**KIRKLEES METROPOLITAN COUNCIL
INVESTMENT & REGENERATION SERVICE**

Reference No: 2021/62/92068/W

Site Address: 7, Fenay Crescent, Almondbury, Huddersfield, HD5 8XY

Description: Erection of two storey side and rear extensions and single storey front extensions (modified proposal)

Project:	FENAY CRESCENT ALMONDBURY	Job No:	2020-002
Title:	PROPOSED PLANS		
Scale:	1:50@A1	Drawn by:	
Date:	05.05.21	Checked by:	-
Drawing No:	(20)002	Revision No:	-

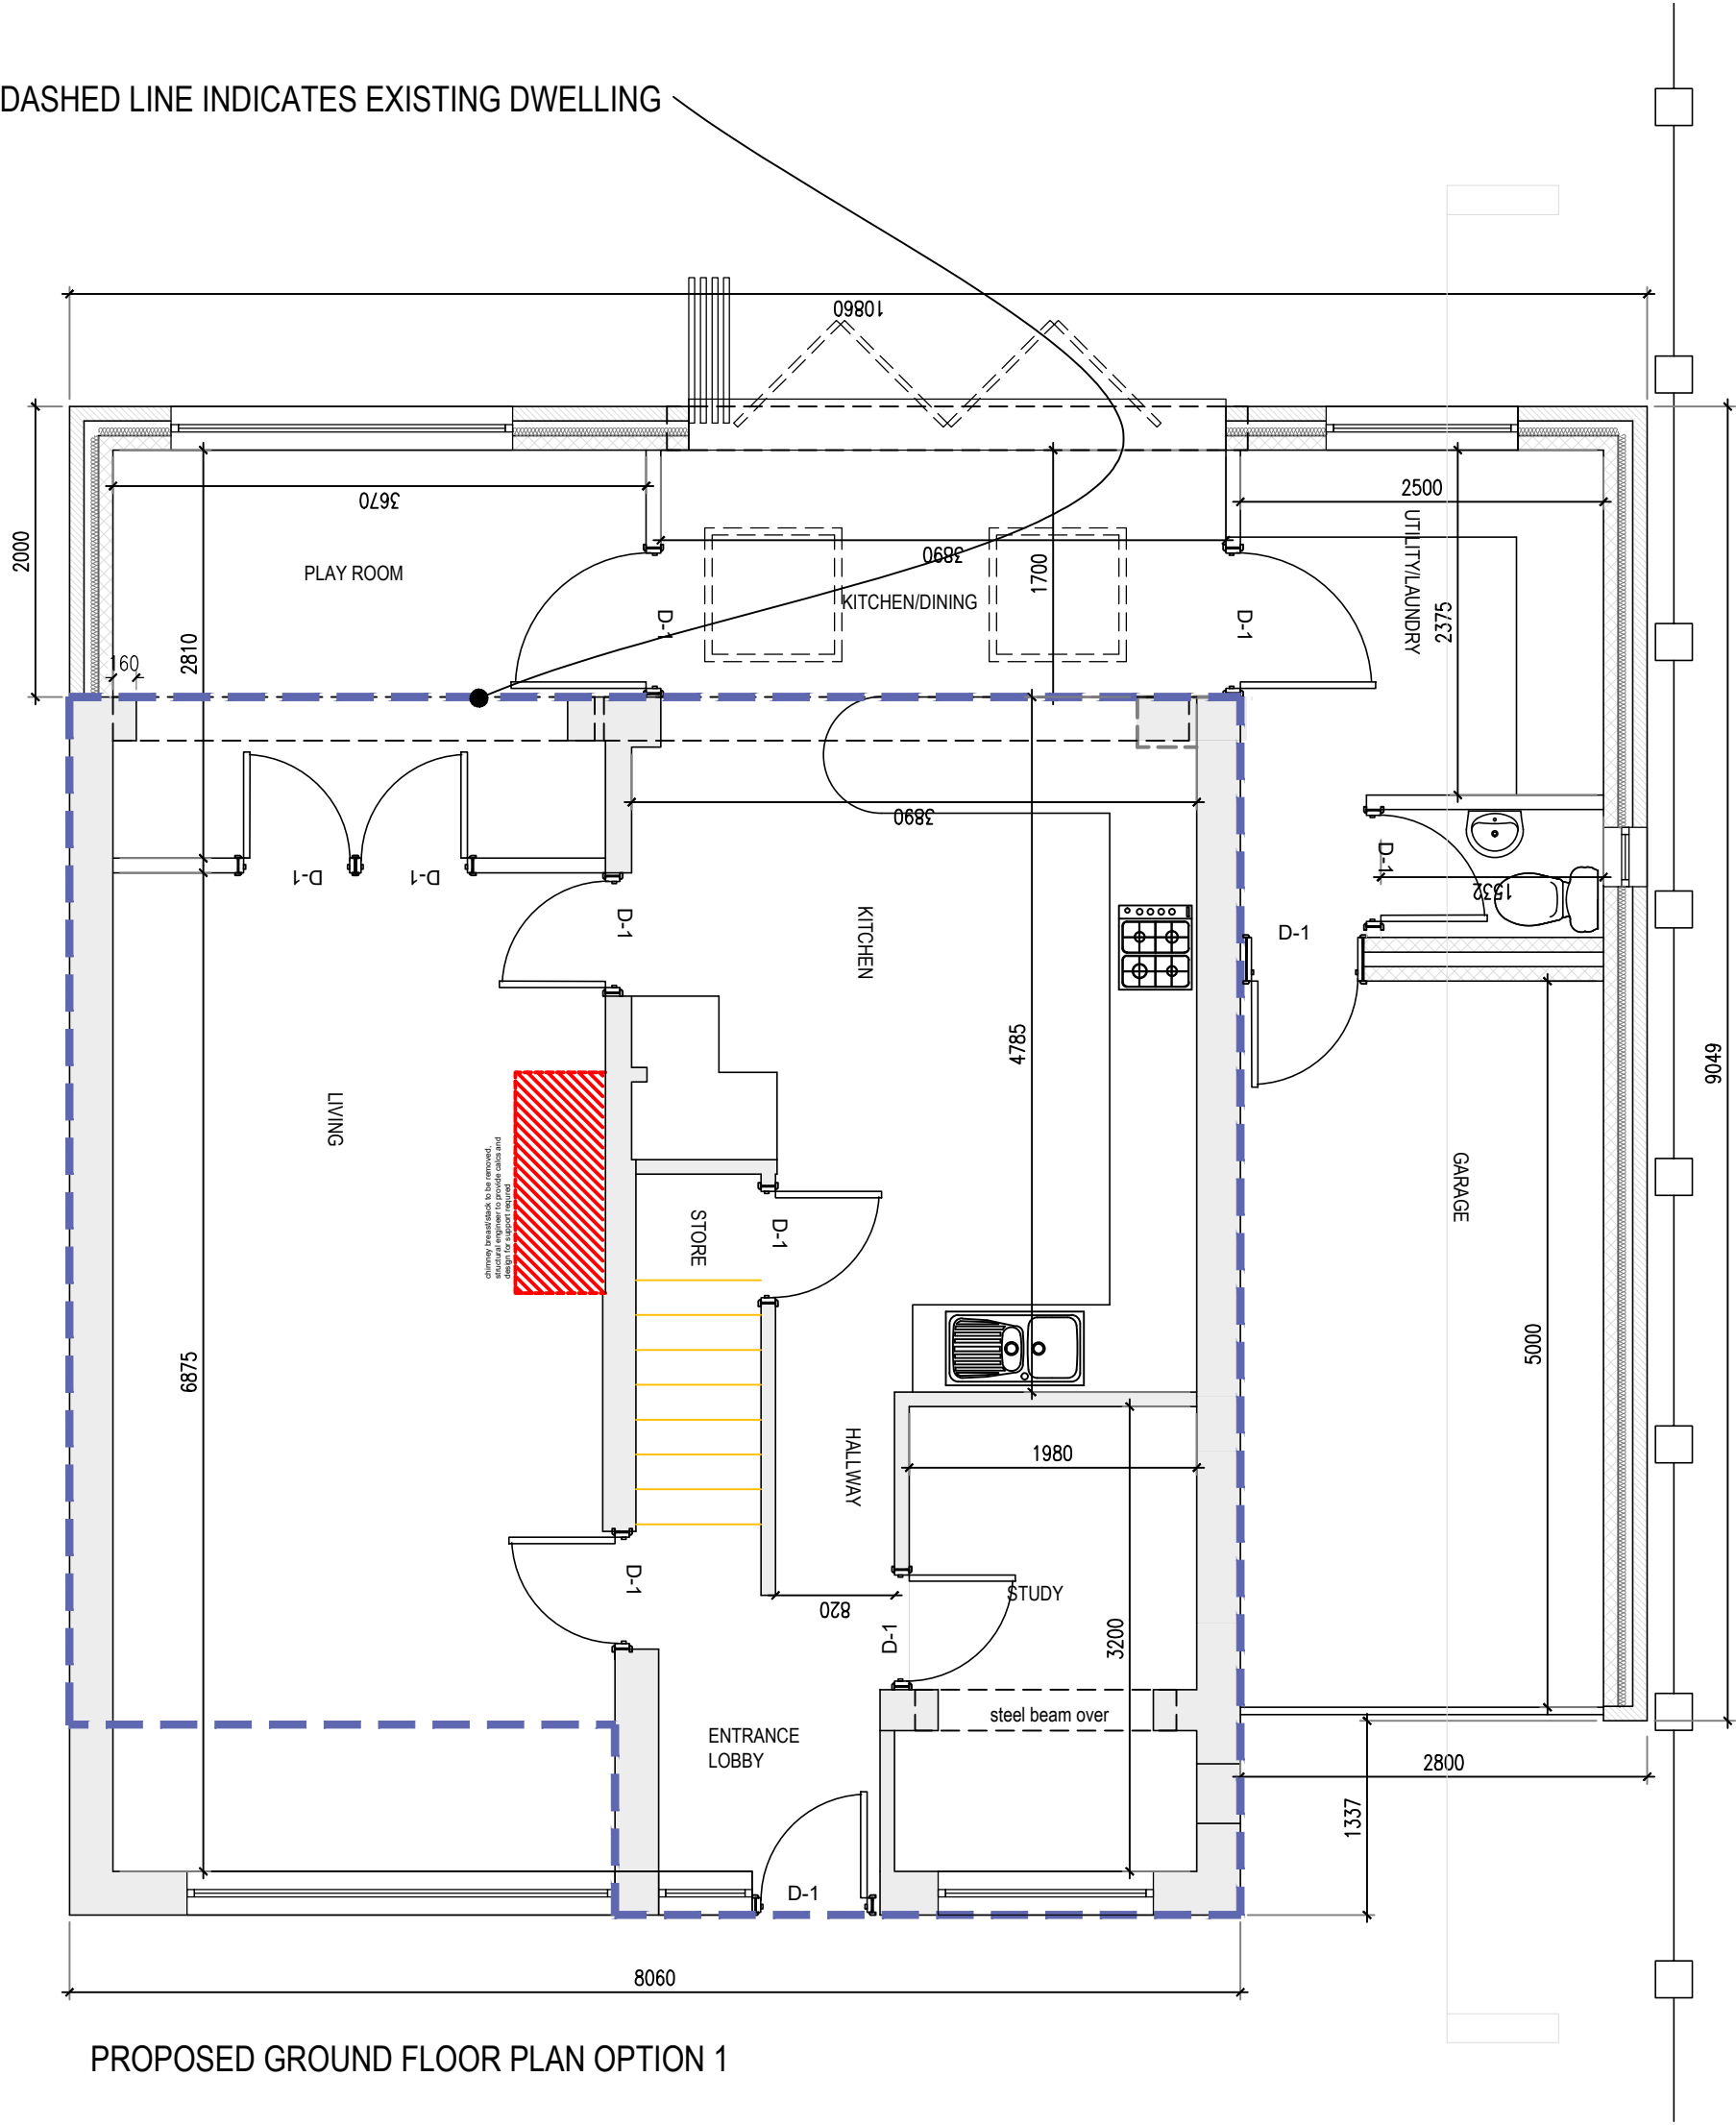
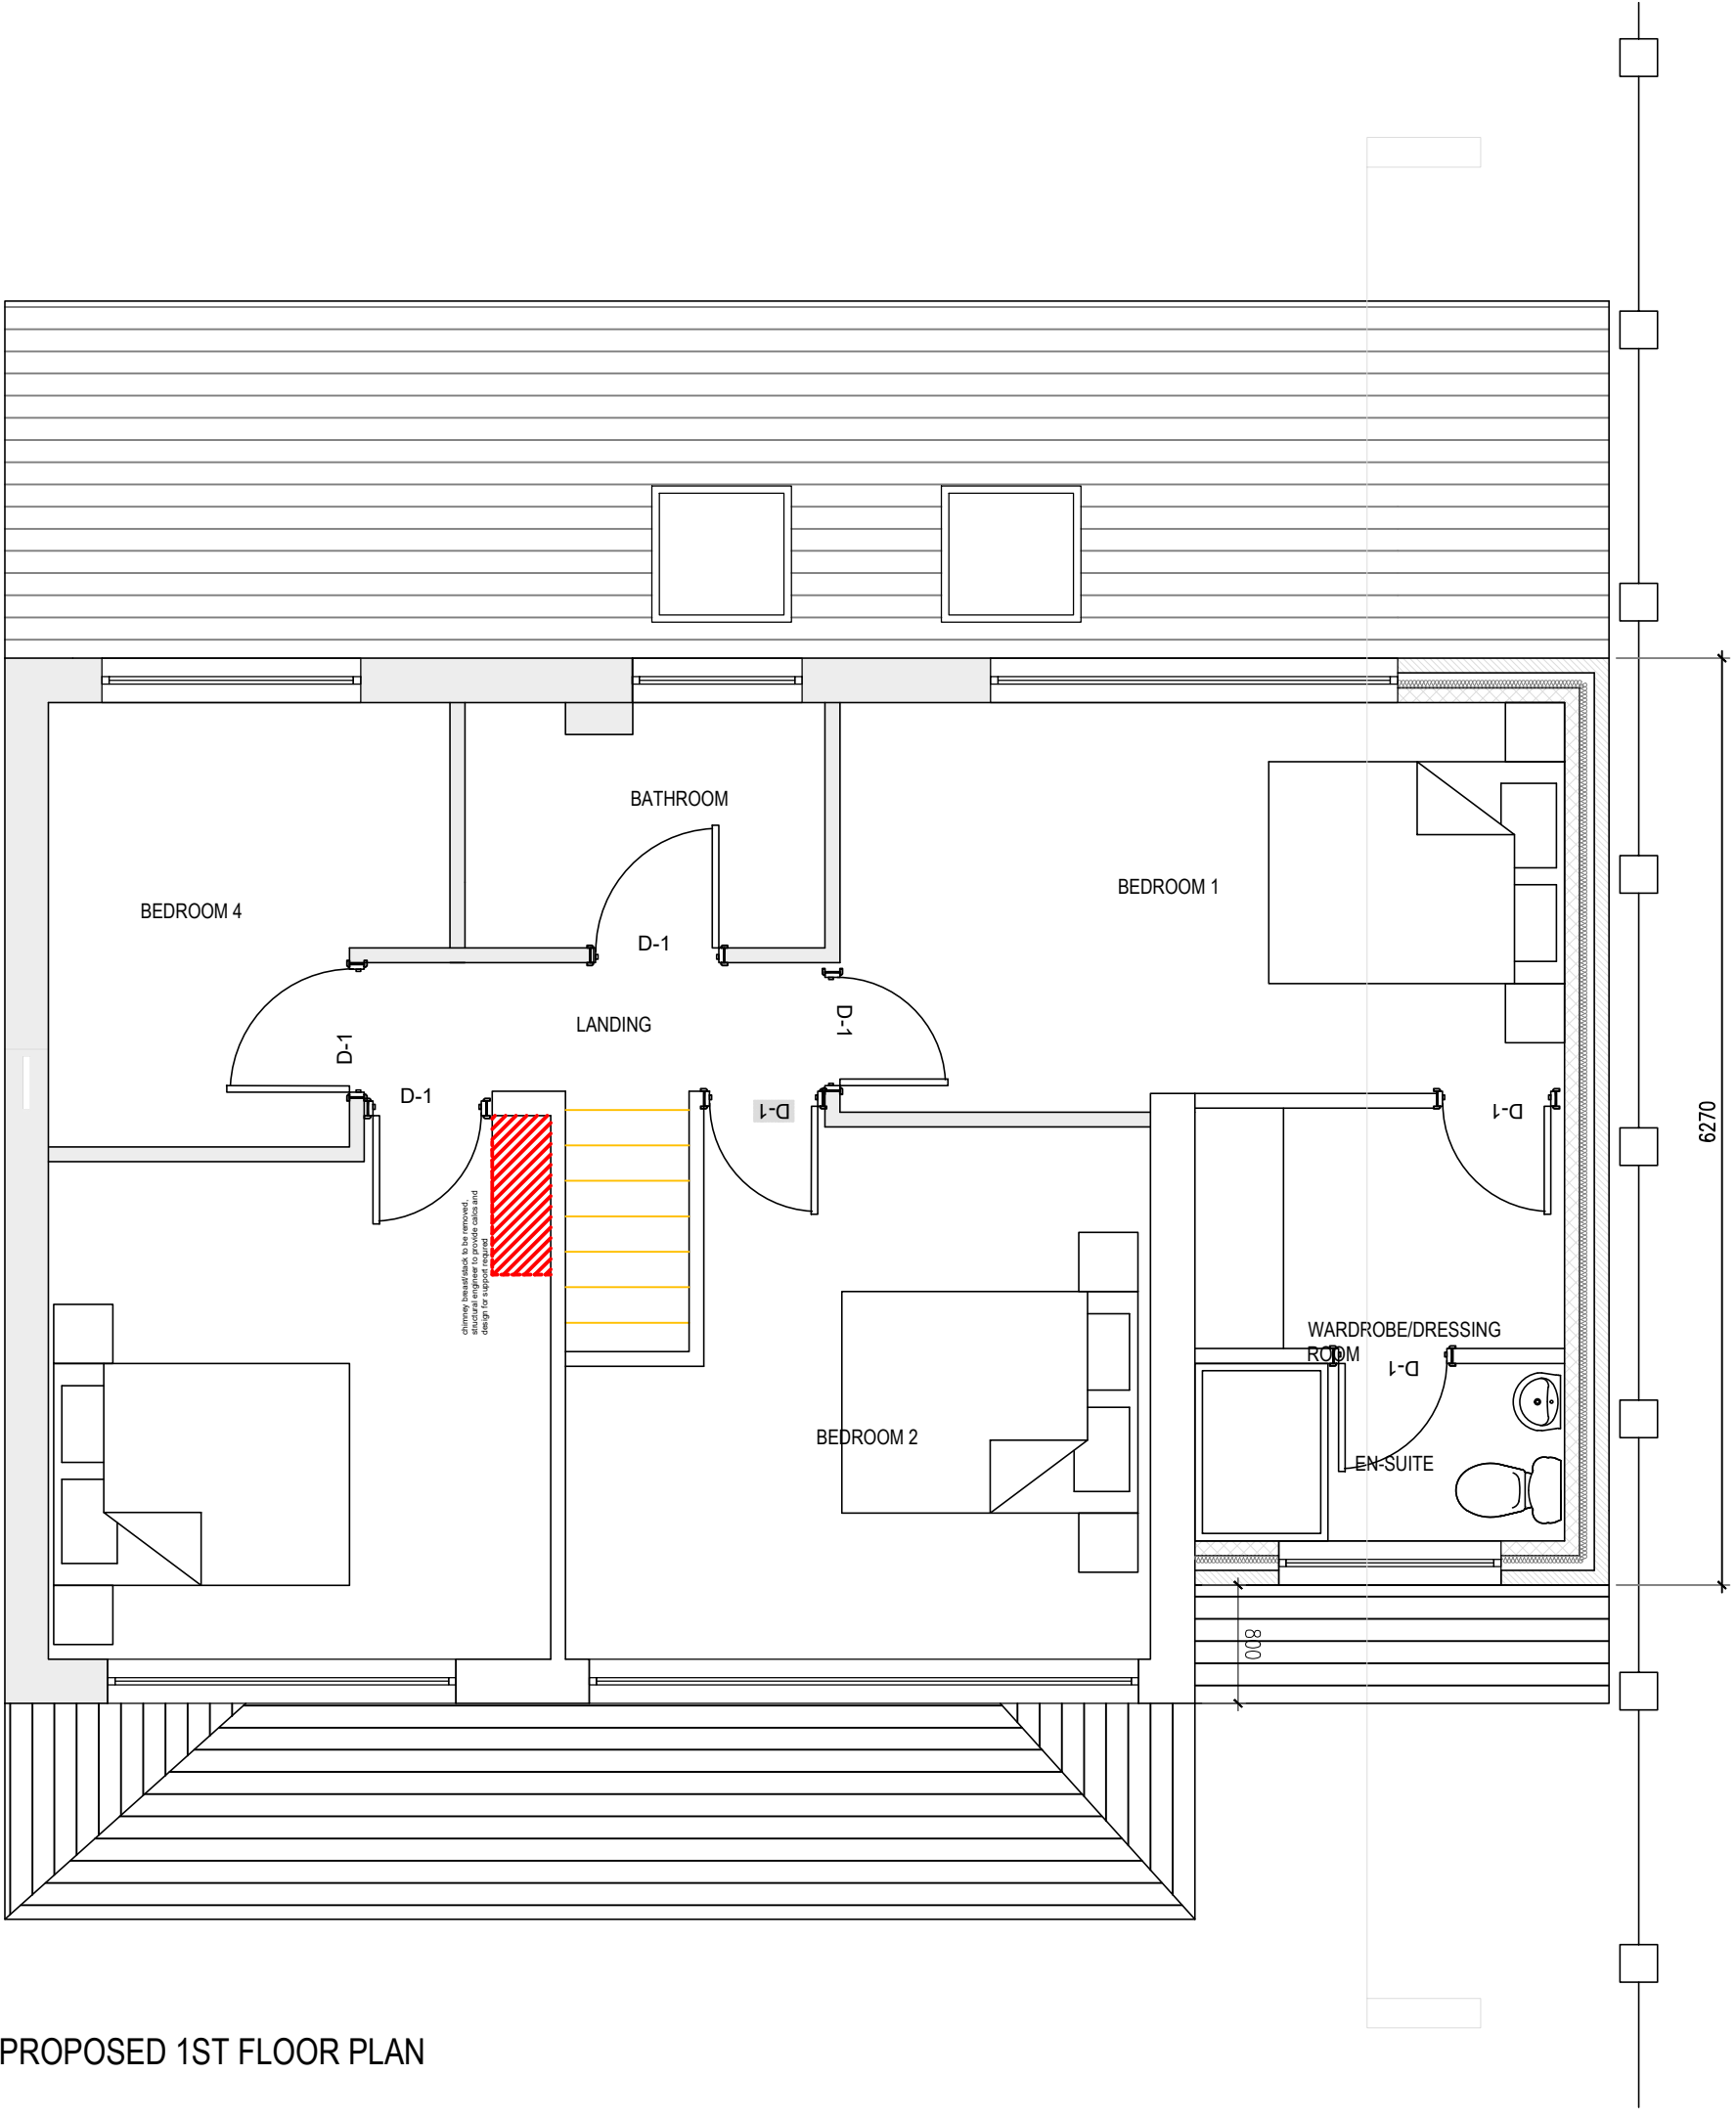
In terms of highway safety, the new garage would have internal measurements of 2.4m wide by 5m long which is narrow but would accommodate a small car, the remaining drive would be approx. 6m long, again could accommodate one car. The agent has submitted an amended plan to create a second space to the front given the reduced internal measurements of the garage, as such would meet the aims of Policy LP22 of the Kirklees Local Plan with respect to highway safety and advice in Chapter 12 of the National Planning Policy Framework.

4. The proposed additional parking space detailed on Dwg. No. (20) 002 shall be provided at the front of the property before the development is first brought into use and thereafter retained, all areas indicated to be used for parking on the submitted plans shall be finished in a hardened and drained surface in accordance with the Communities and Local Government; and Environment Agencies 'Guidance on the permeable surfacing of front gardens (parking areas)' published 13th May 2009 (ISBN 9781409804864) as amended or any successor guidance. Notwithstanding the provisions of the Town and Country Planning (General Permitted Development) Order 2015 as amended (or any Order revoking or re-enacting that Order) these areas shall be so retained, free of obstructions and available for the use specified on the submitted plans.
